Development Application

Hornsby & Ku-ring-gai Hospital Development Stage 1

Application No :- SSD5356

Appendix 1

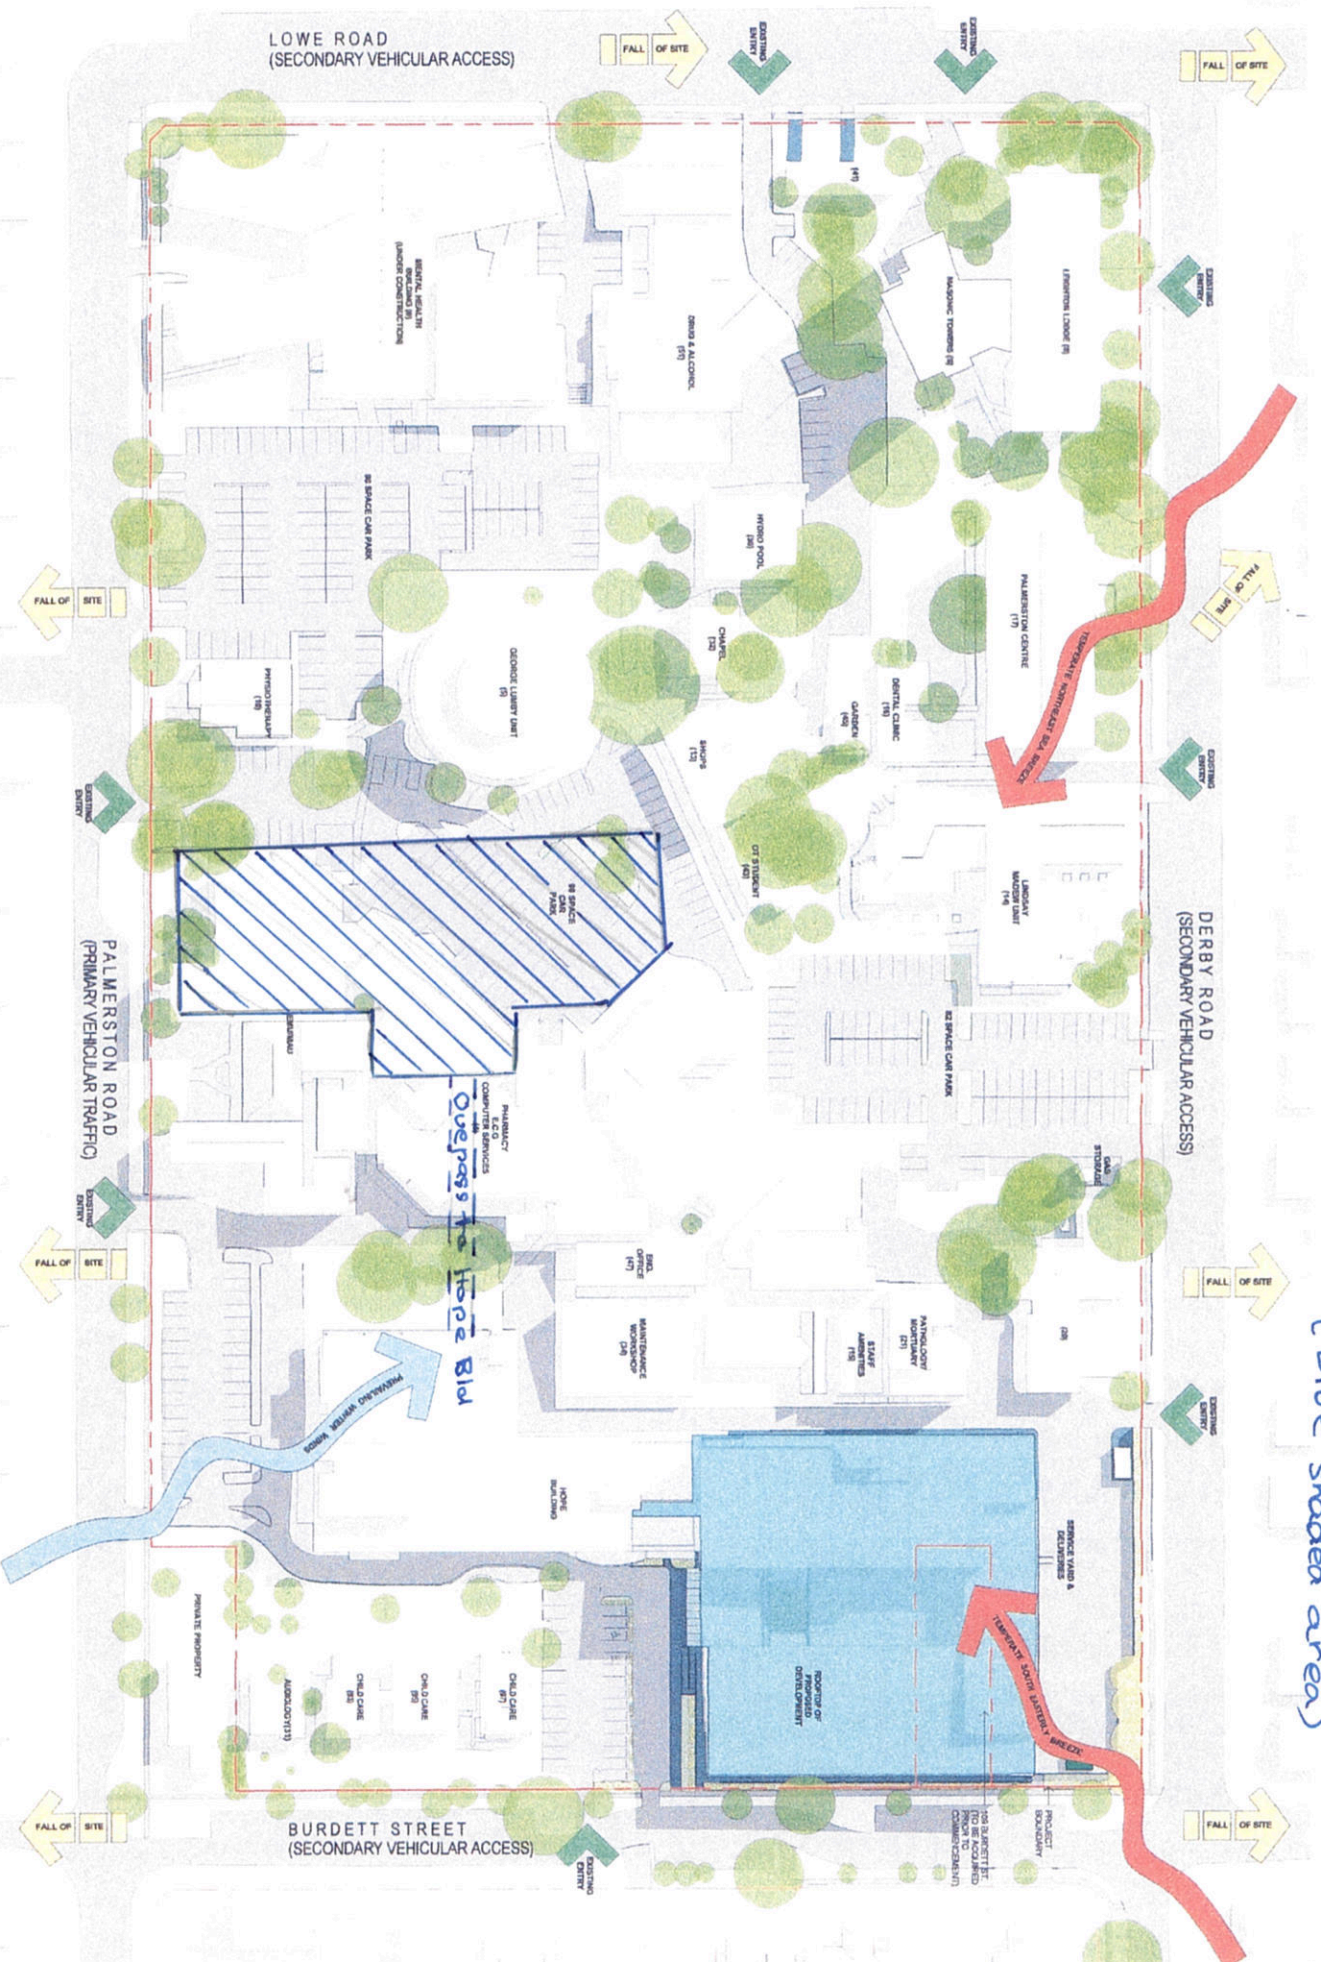
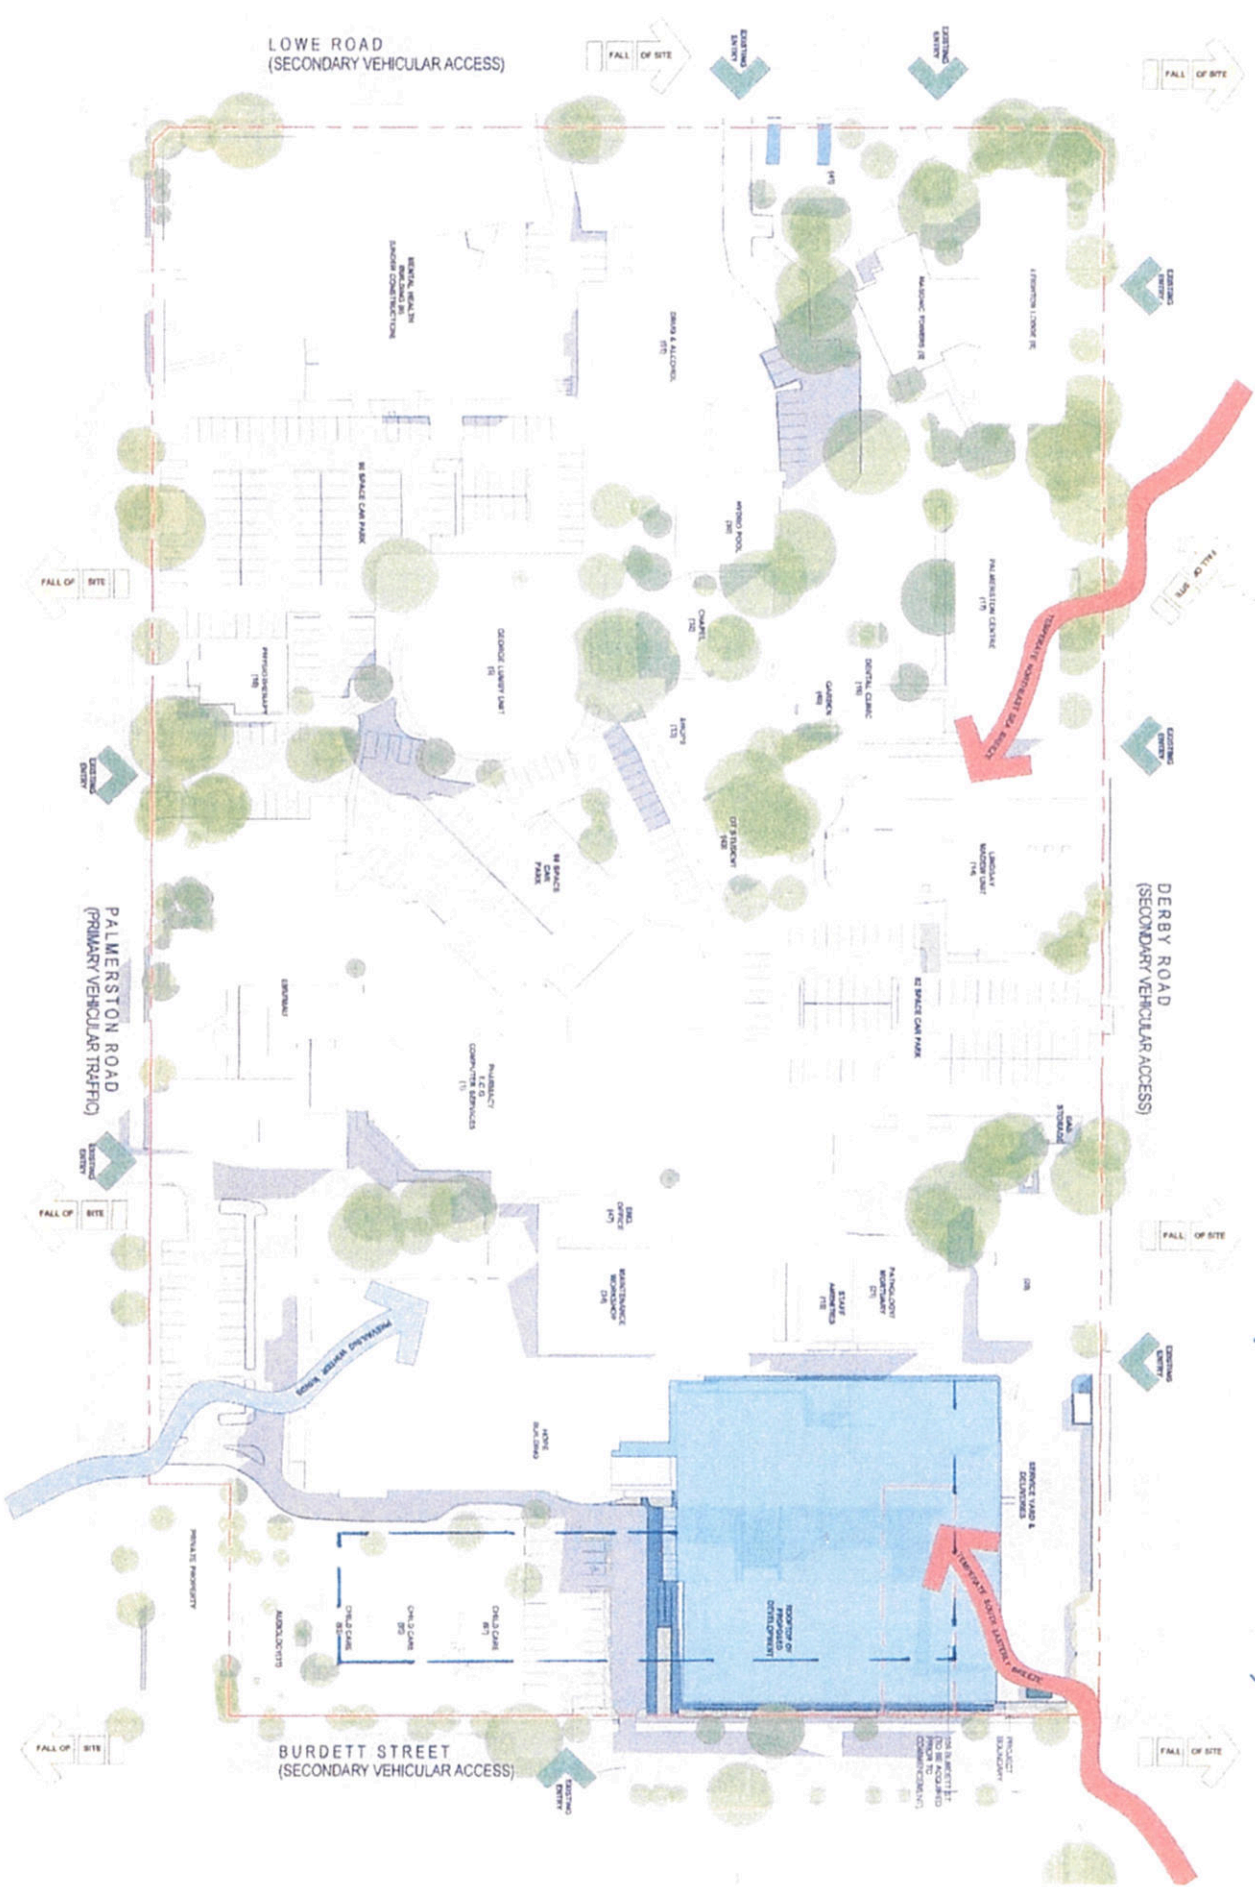
Stage 1. Is planned in the wrong area, this should be the last to be developed. This stage should be in the now new car park in the centre of the campus. The building should be built

Building in the middle of Campus USING SAME GRIDLINES, A core rectangular building, without voids, could be built with approx. the same amount of money. All services that are needed are all nearby. A draftsman from infrastructure could redraw amended plans without an architect.
